To: Cherwell District Council

Planning Application No.	13/01584/F	Planning Officer	Andrew Lewis
Date	12 th December 2013	OCC Officer	Judy Kelly

Location: Parcel B2A Camp Road Upper Heyford

Description: Erection of 69 dwellings with associated car parking, infrastructure and landscaping, provision of public open space, play areas and flood attenuation

Bir.4372_02B

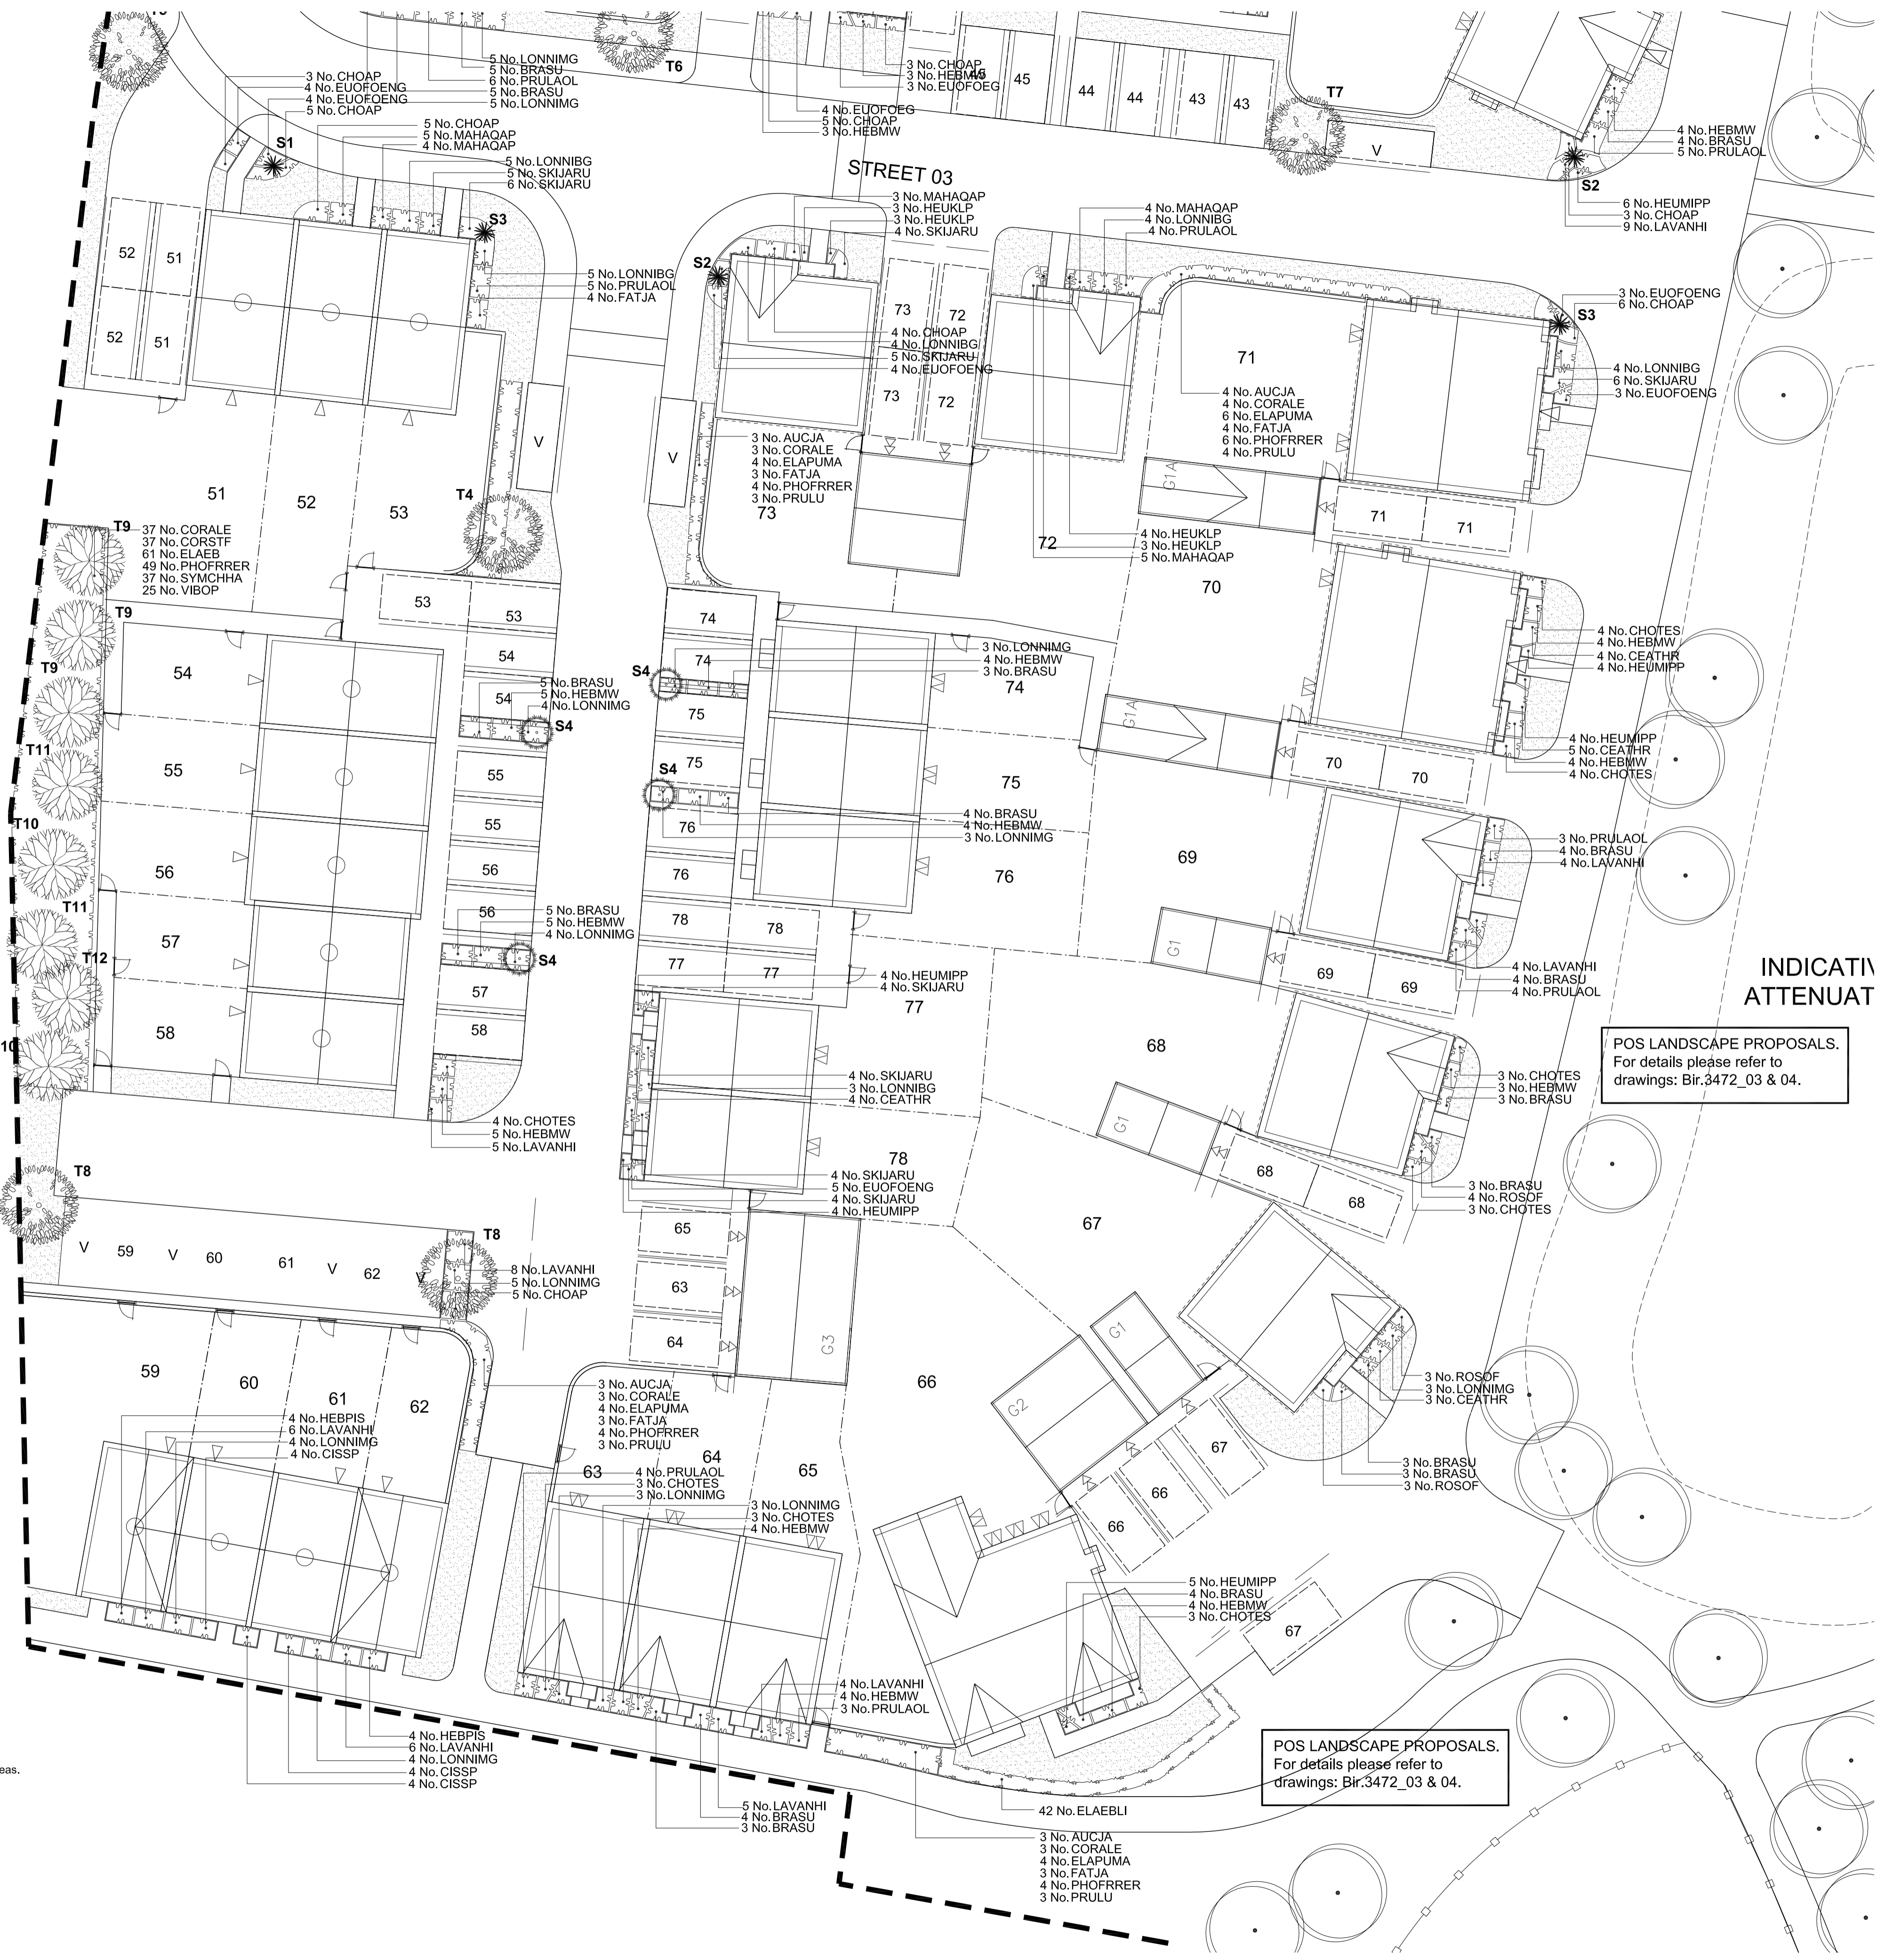
With regard to the planting along the southern side of Camp Road, either side of the new entrances, there may be some concerns for vision splays and would suggest that Darren Hemmings (Arboricultural Officer) is consulted as to the planting on this stretch, species and the future maintenance. Also these new entrances show what appear to be hedges along the edge of the cycle path. This also could cause visibility issues and in the current climate we would not wish to take on any vegetation that would need a lot of maintenance.
